**Board Direction**  
**ABP-304774-19**

**WHEREAS** a question has arisen as to whether the decorative works to the front elevation of the Royal Irish Yacht Club, Harbour Road, Dún Laoghaire is or is not development or is or is not exempted development:

ELEVATION PRIOR TO PAINTING

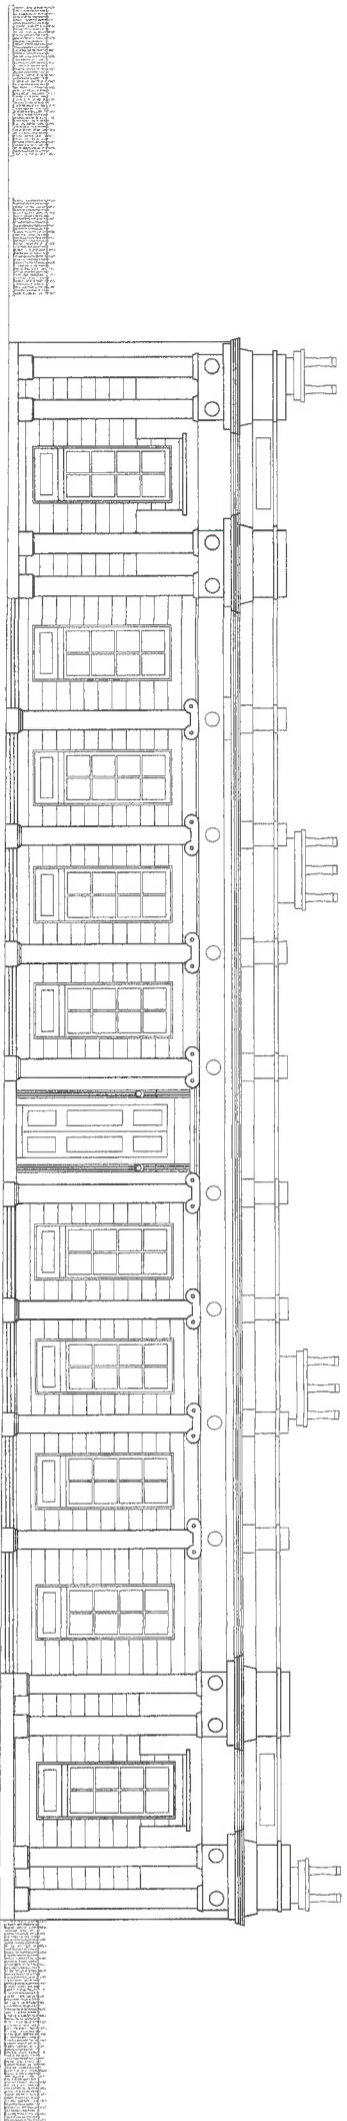
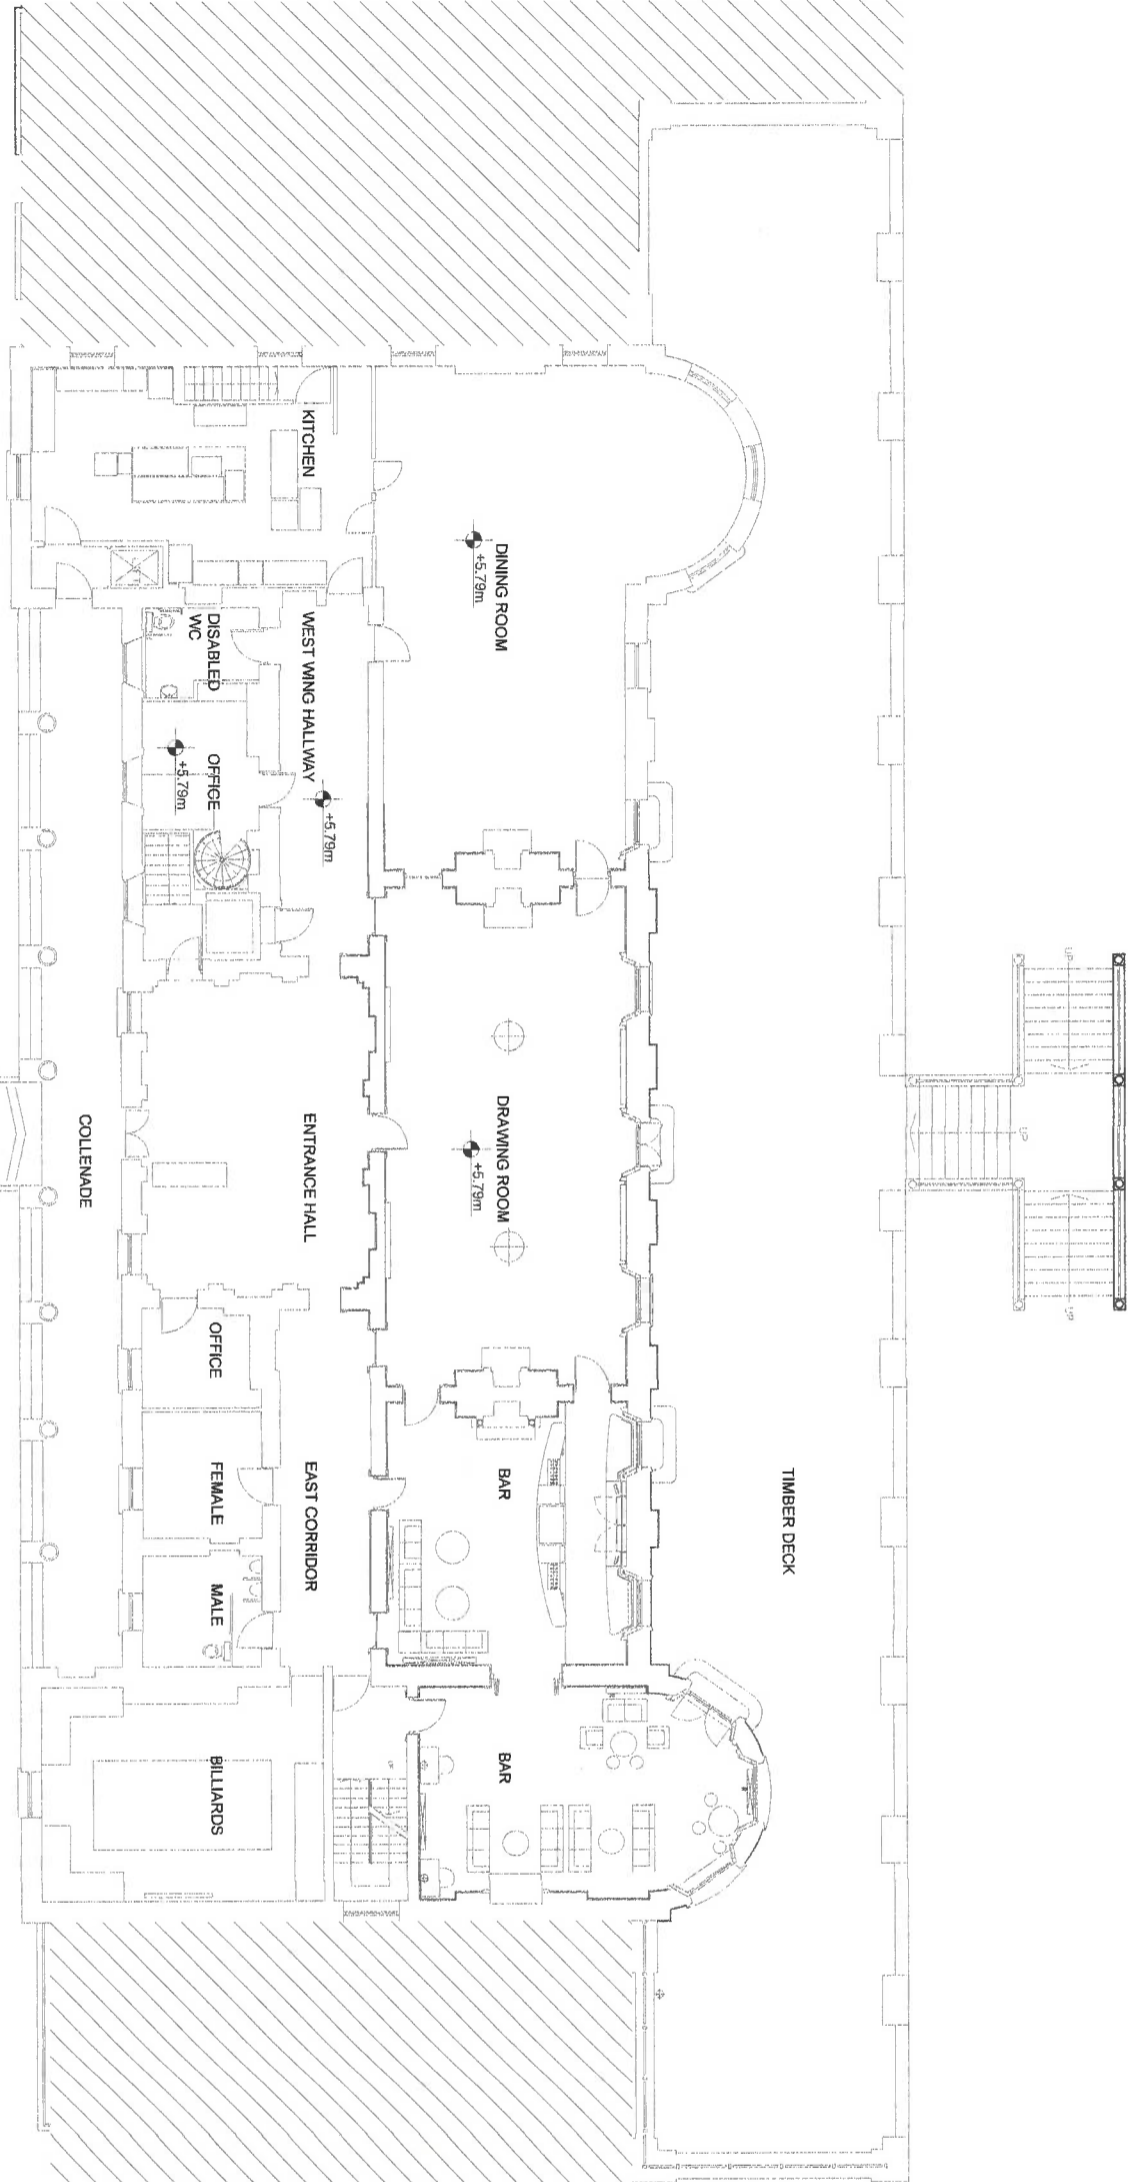
- (a) the works of painting of all walls within the entrance portico of the building a blue-grey colour constitute development which comes within the meaning of section 2(1) and section 3(1) of the Planning and Development Act, 2000, as amended,

- (c) such development would materially affect the external appearance of the structure so as to render the appearance inconsistent with the character of the structure, and would materially affect the character of the Royal Irish Yacht Club protected structure, the uniform off-white paint finish to the exterior is an element of the structure which contributes to its special architectural interest,

**NOW THEREFORE** An Bord Pleanála, in exercise of the powers conferred on it by section 5 (3) (a) of the 2000 Act, hereby decides that the said works to the front elevation of the Royal Irish Yacht Club, Harbour Road, Dún Laoghaire, specifically the painting of all walls within the entrance portico a blue-grey colour is development and is not exempted development.
